**WELWYN HATFIELD BOROUGH COUNCIL  
EXECUTIVE DIRECTOR - PLANNING, PUBLIC PROTECTION AND GOVERNANCE**

**DELEGATED APPLICATION**

**Application No:** 6/2020/0715/HOUSE  
**Location:** Peartree House 38 High Road Essendon Hatfield AL9 6HW  
**Proposal:** Erection of single storey side infill extension and front porch  
**Officer:** Ms Lucy Hale

**Recommendation:** Granted

No. DD2785-1 SHT 1/2

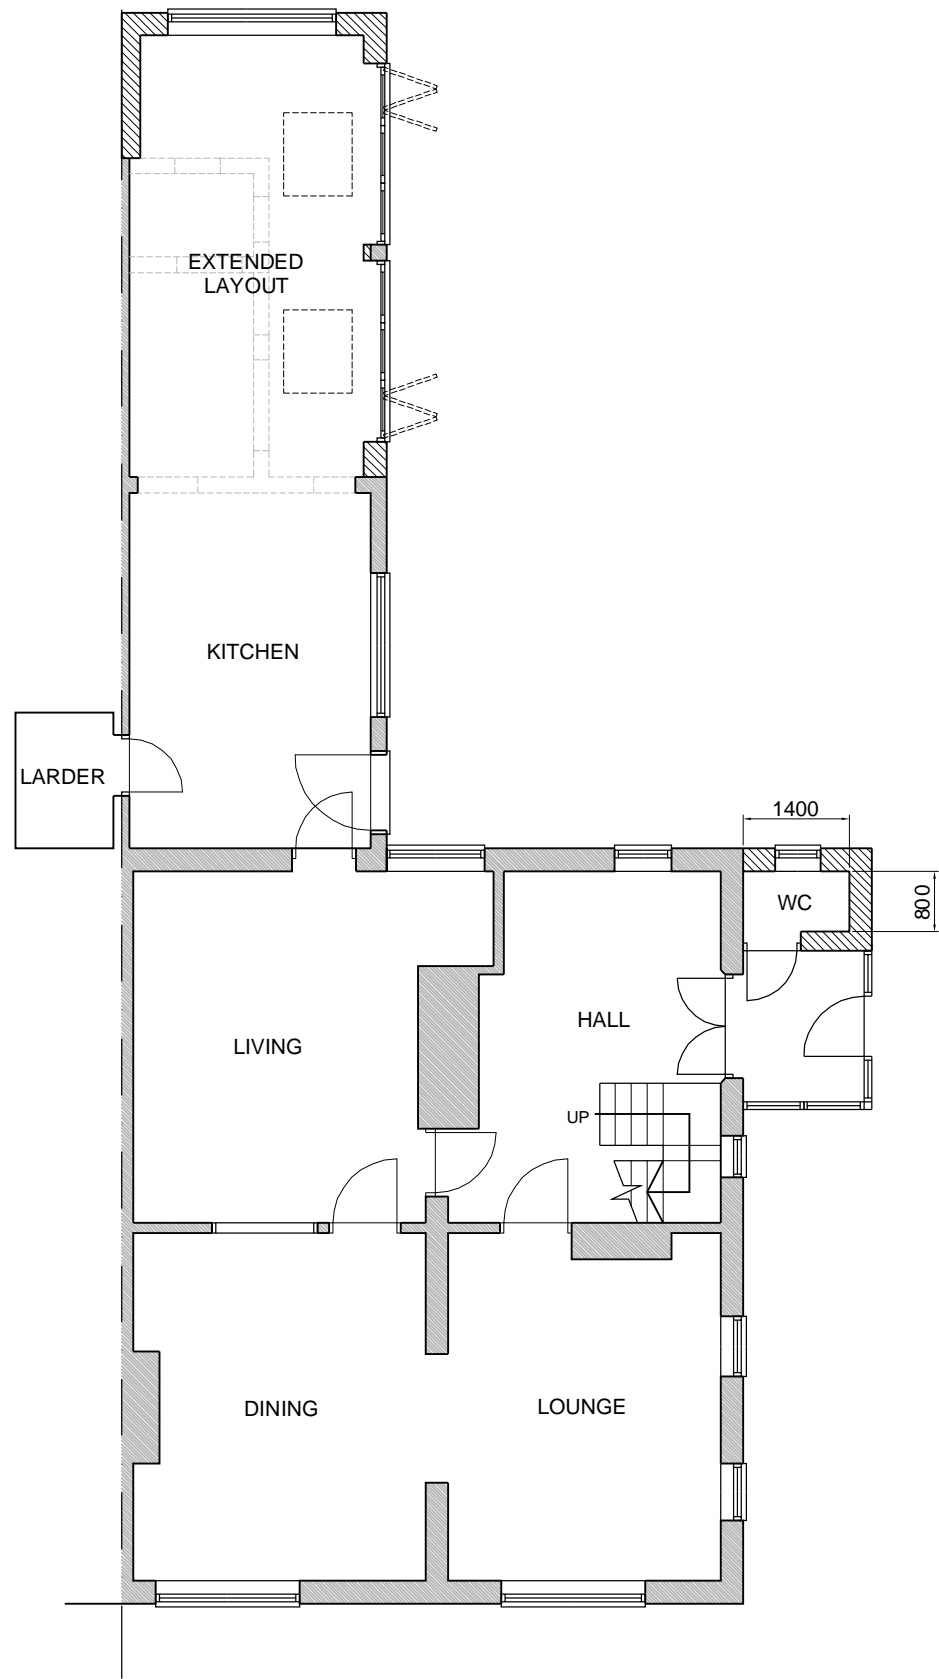
The proposal would involve the bricking up of the partially open sided extension to the rear to create an additional enclosed living space. The brickwork would match the existing dwelling and roof lights and glazing would be added to the roof. The footprint of the extension would not increase beyond the profile of the roof canopy. The proposed alterations would reflect the design and character of the dwelling and remain subordinate in scale. This element of the proposal would not be visible from the street scene and consequently would preserve the character of Essendon Conservation Area.

In addition, a small flat roof porch is proposed behind the existing pitched roof porch to the side of the property. This addition would be modest in size and matching in material and therefore would not result in harm to the appearance of the dwelling. Furthermore, it would be set back from the highway and tucked behind an existing extension. It is considered to adequately preserve the character and appearance of the Essendon Conservation Area.

The original footprint of the dwelling was approximately 122sqm. Previous extensions to the side with a small porch and detached garage have increased the footprint by approximately 36sqm equating to a 27% increase. The proposed infill to the rear would not increase the footprint of the dwelling. The addition to the porch would increase the footprint of the dwelling by approximately 2.2sqm. It is considered that the design, scale and location of such works would not amount to disproportionate additions over and above the size of the original building in both quantitative and qualitative terms. Therefore, it is considered that the proposal would not result in a disproportionate addition to the original dwelling and would therefore represent an appropriate form of development in

1. The brickwork, roof tile, bond, mortar, windows, detailing, guttering, soffits and other external decorations of the approved extensions must match the existing dwelling in relation to colour and texture.
